From: Ian Brewster
Sent: 04 April 2011 12:57
To: Janice Chapman
Subject: RE: BR/65/11/T 2 Queens Square Glamis Street Bognor Regis PO21 1SA

Ian Brewster | Principal Arboricultural Officer, Greenspace, Engineering and Emergency Planning, Arun District Council |
Location: Town Hall, Clarence Road, Bognor Regis, West Sussex, PO21 1LD

Site Plan

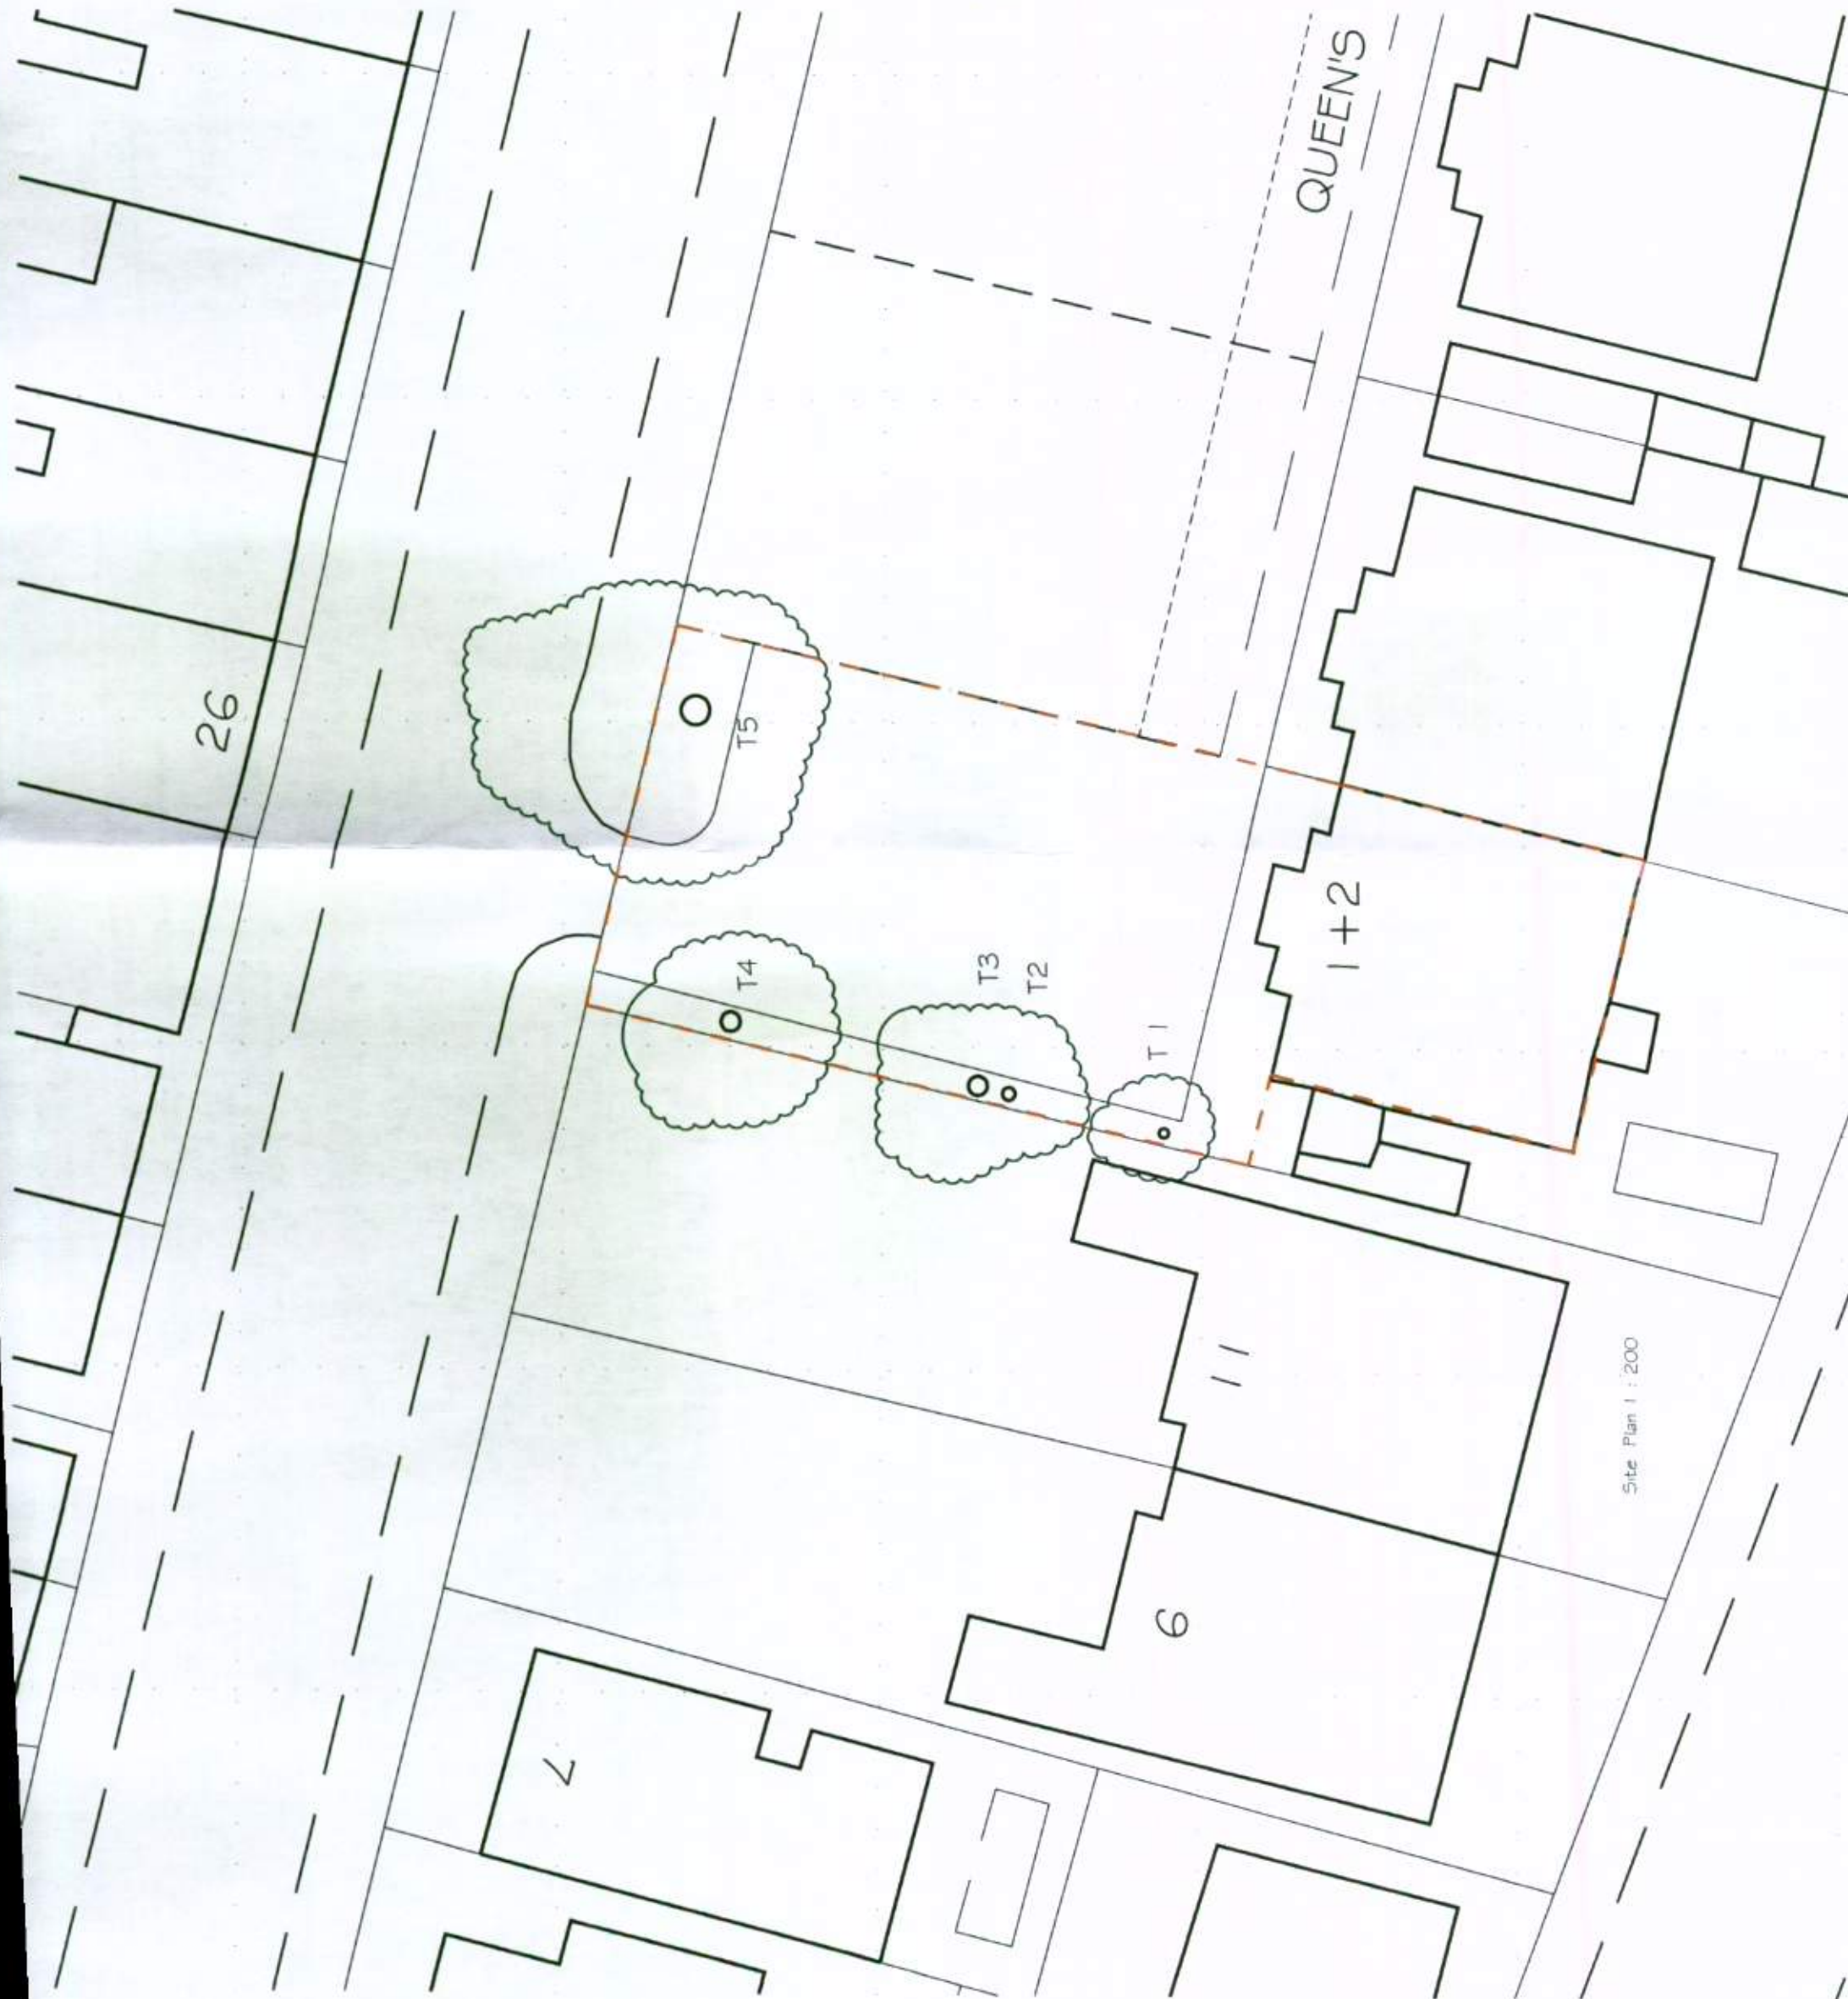
the above application does not provide justification for the removal of T1 Lime. The tree is the smallest of the other four trees and appears to have been pollarded at a height of approximately 4-5m at least 30 years ago. There is dense branch growth were some grow near to the building. It is recommended that this tree is crown reduced, allowing for 4m to be cut from the branch tips inwards towards the main stem. The severance of Ivy at the tree base may help alleviate the shade nuisance and should be considered.

The other four trees appear mature and lack vigour were the majority of active crown growth appears to be around the periphery of the crown. There is little inner crown growth to prune back to. It is recommended that the other four trees T2, T3, T4 and T5 have minimal works. The work should consist of

5.5m crown lift, restricting the removal of branches with stem diameters to not exceed 100mm.

There are telephone wires which pass through the crowns of the trees and branch growths should be pruned to provide a minimum distance of 1m, restricting the removal of branches with stem diameters to not exceed 100mm.

There are some dead branches and stubs within the crown which should be removed as part of the above work.
